Planning Application - Anglian Water Response

AW Site Reference: 225890/1/0232840

Site: Land off Postland Road
Crowland

Proposal: Proposed development of 9
Dwellings

**Drainage Strategy**

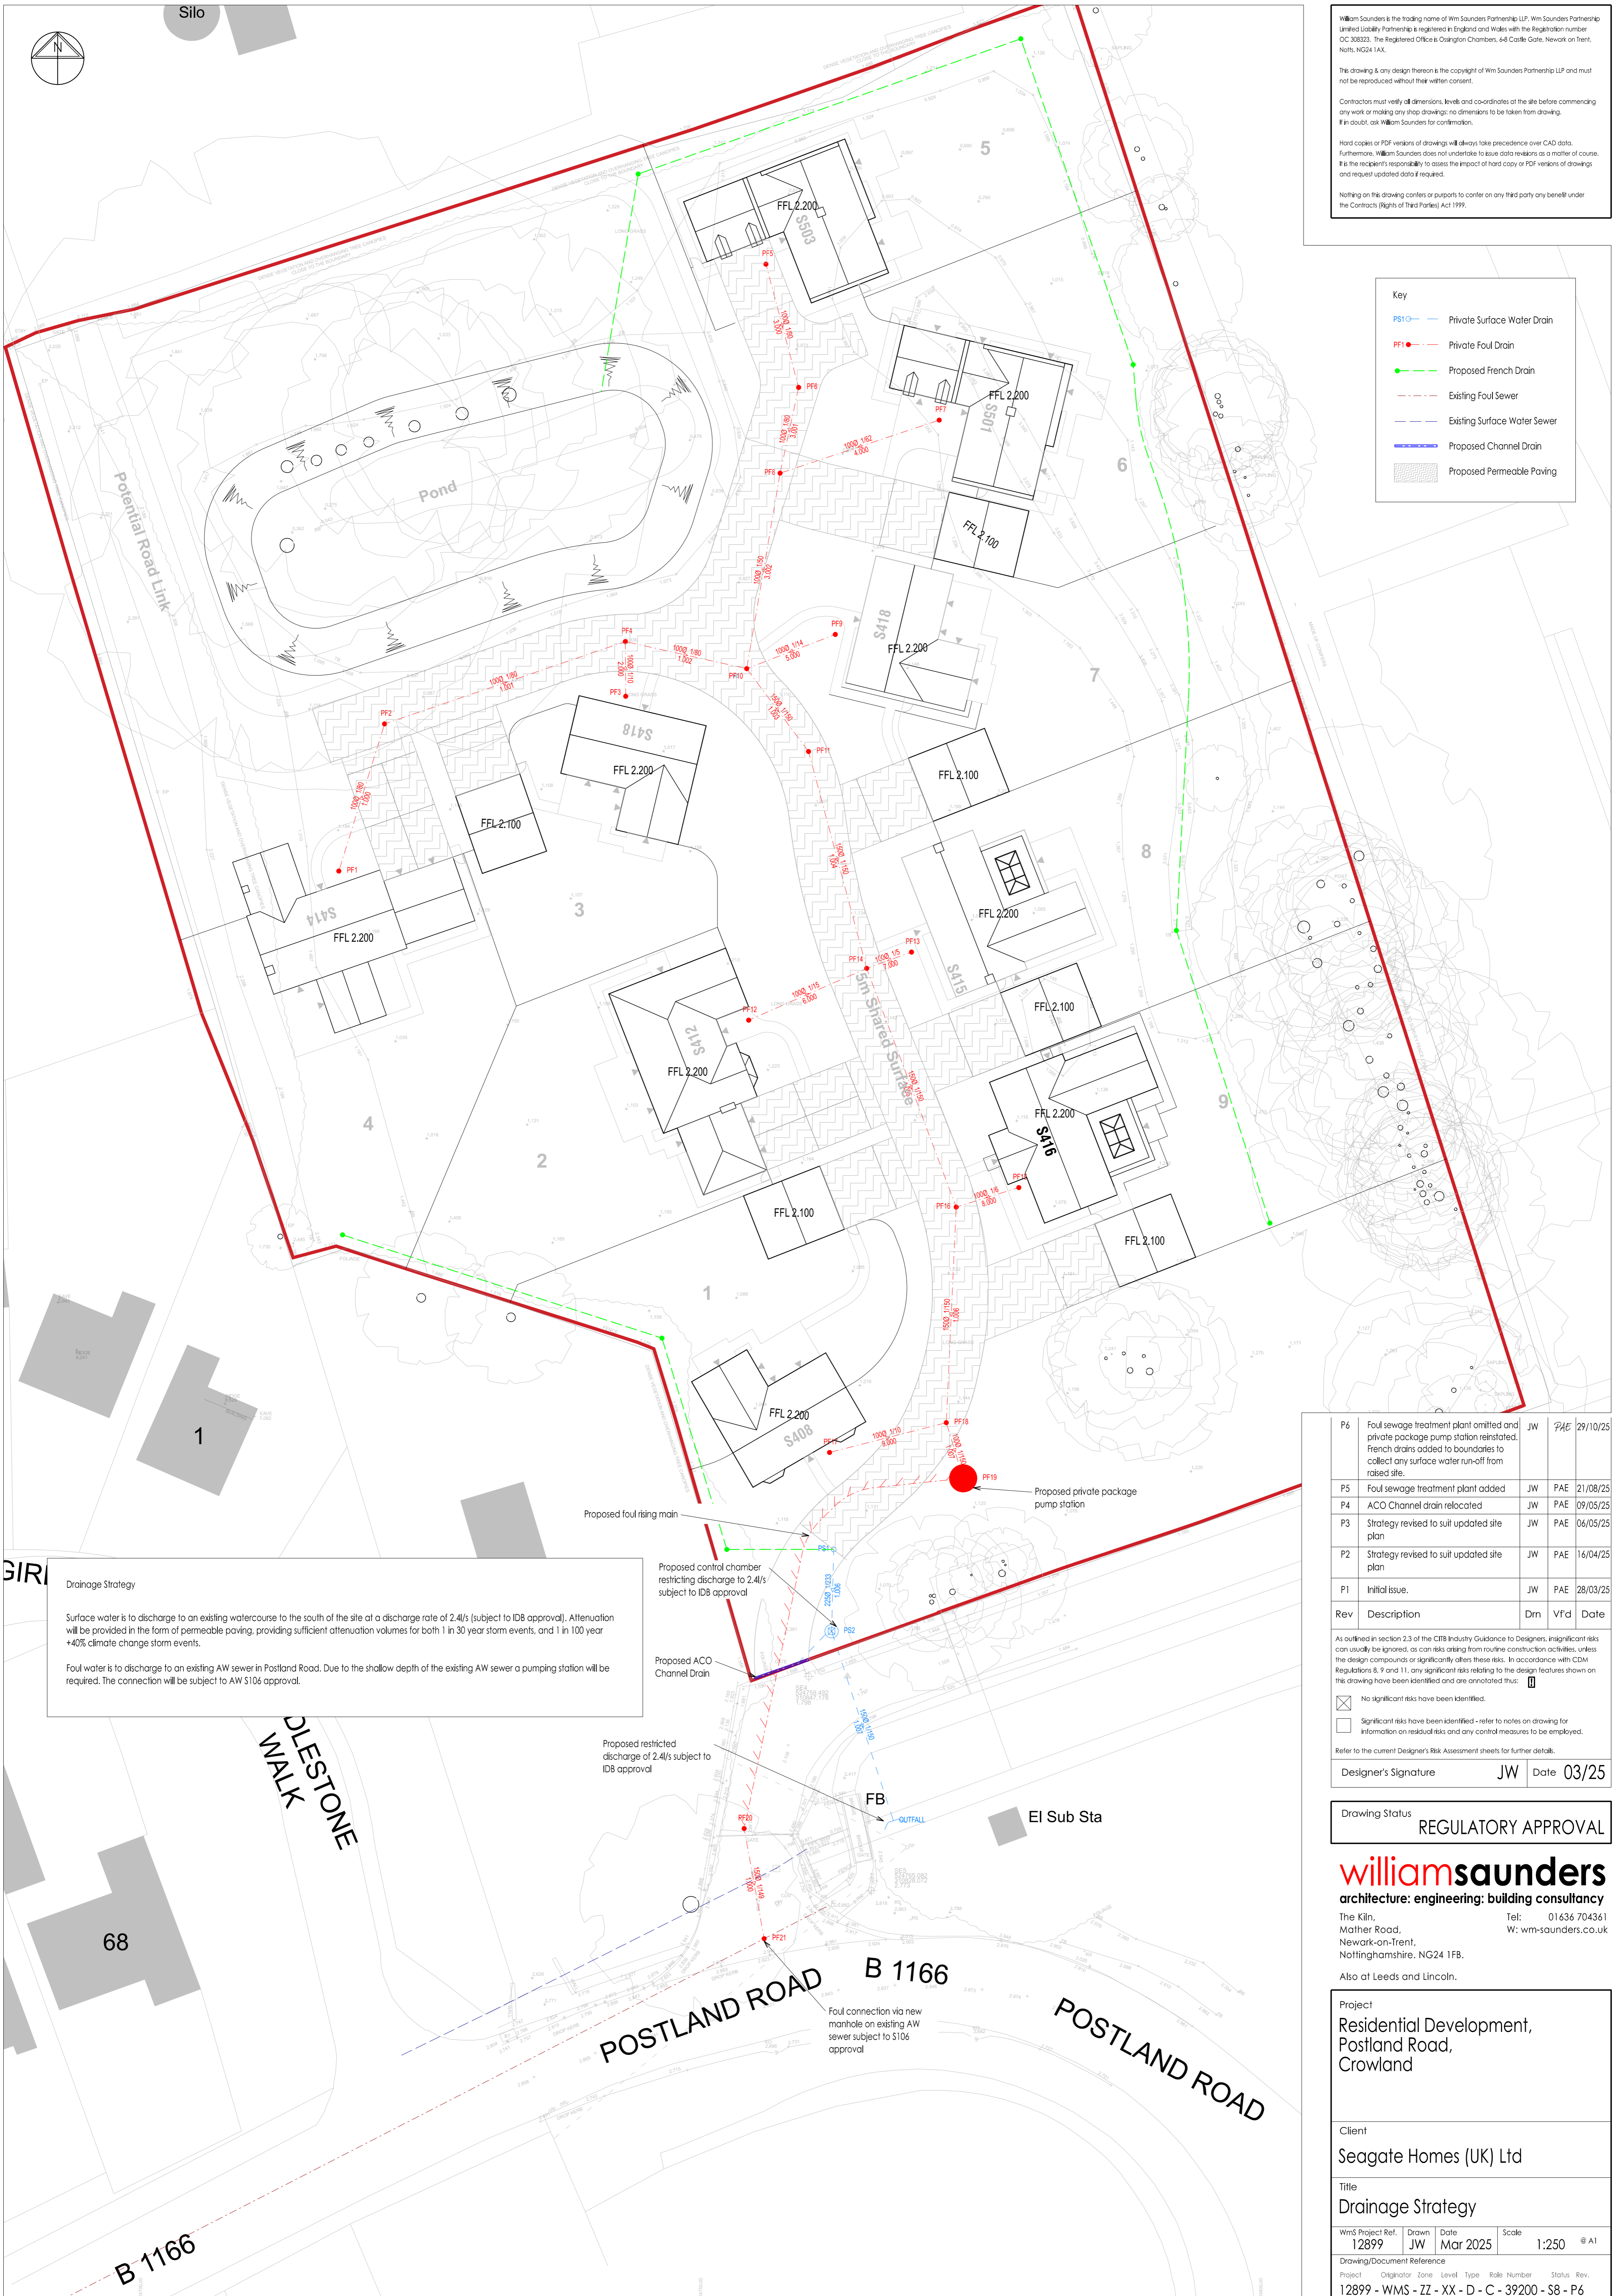
Anglian Water has reviewed Drainage Strategy 12899 - WMS - ZZ - XX - D - C - 39200 - S8 - P5 it is stated that the applicant now proposes to utilise a private sewerage treatment plant that will discharge directly to the adjacent watercourse. It is understood that the amended drainage strategy would be subject to review and response by the Environment Agency, as part of this application and a separate approval process would be required. At this stage, it is not clear whether this alternative method is an acceptable solution which could be implemented to deal with foul drainage, therefore we would recommend a condition if the application is approved:

Anglian Water has reviewed the Drainage Strategy 12899 - WMS - ZZ - XX - D - C - 39200 - S8 - P5. The applicant is now proposing to discharge foul drainage with a Sewage treatment Plant. This alternative proposal does not require a connection to Anglian Water and our agreement is not being sought on this. However, for the avoidance of doubt, should the drainage strategy be considered acceptable to the Environment Agency going forward and planning permission granted on this application, we would require that the Drainage Strategy 12899 - WMS - ZZ - XX - D - C - 39200 - S8 - P5 is included in the list of approved drawings and documents within the Decision Notice. In the event that the proposed foul water drainage strategy management changes to include interaction with Anglian Water operated assets, we would require that we be re-consulted to ensure that an effective sustainable point of connection for the site is prepared and implemented.

From the details submitted to support the planning application the proposed method of surface water management does not relate to Anglian Water operated assets. As such, we are unable to provide comments on the suitability of the surface water management. The Local Planning Authority should seek the advice of the Lead Local Flood Authority or the Internal Drainage Board. The Environment Agency should be consulted if the drainage system directly or indirectly involves the discharge of water into a watercourse. If planning permission is granted, the strategy should be listed within the decision notice with any approved plans. Should the proposed method of surface water management change to include interaction with Anglian Water operated assets, we would wish to be re-consulted to ensure that an effective surface water drainage strategy is prepared and implemented.

Condition: Prior to the commencement of development, full details regarding the on-site package treatment plant must be submitted to and approved in writing by the local planning authority. These details must include the approved permit from the Environment Agency, as well as information about the adopting body and the plan for ongoing maintenance. The development shall be carried out in strict accordance with the approved package treatment plant details prior to first occupation and shall be retained as such thereafter.
